To: [Cleve Hill Solar Park](#)
Subject: Cleve Hill Solar Park
Date: 16 September 2019 08:21:10

My written representations from The Cleve Hill Open Hearing on 10th September 2019 are below.

Habitat Management Areas
Figure 9.3

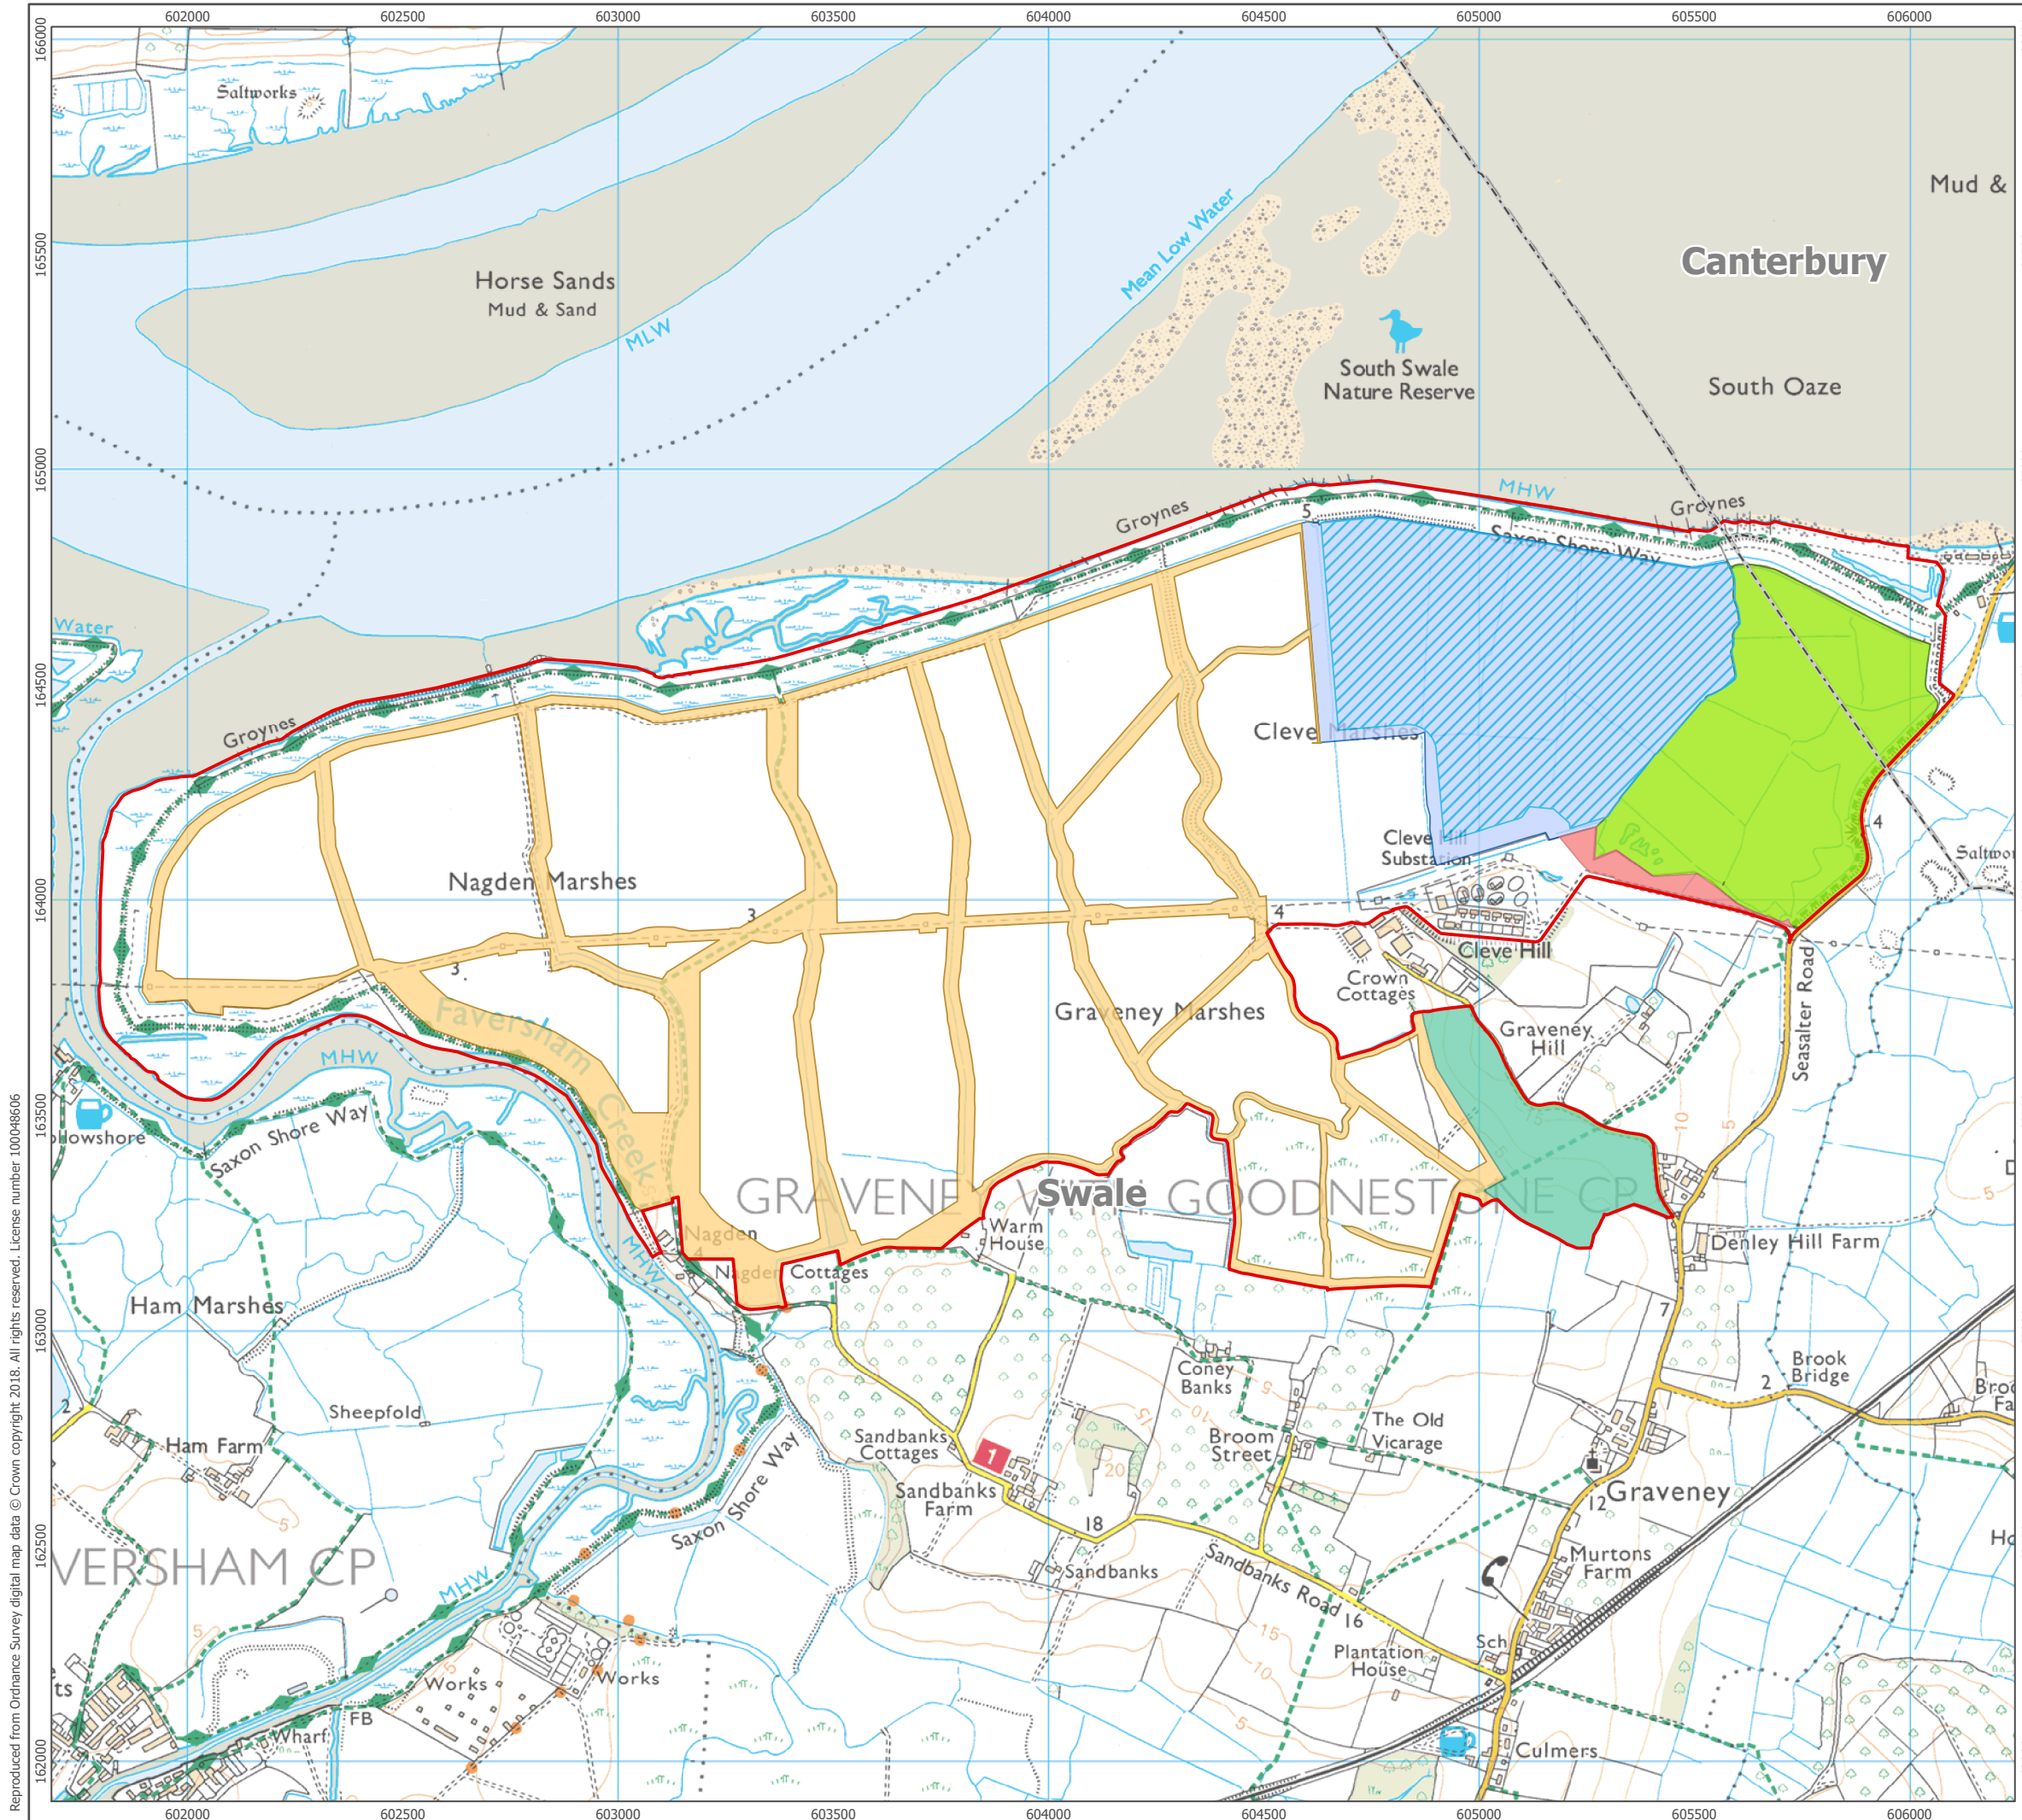
- To the east grazing on the Arable Reversion Habitat Management Area is only April to September
- To the west, which is where I graze sheep, there is no grazing allowed in the winter months
- I am unsure of when grazing will be allowed between the fenced off array to the ditch
- The Grazing under the solar panels is planned to be year round but on a rotational basis. Table 1 in the Microclimate and vegetation Desk-Based Study states that to achieve high biodiversity the area will require careful management
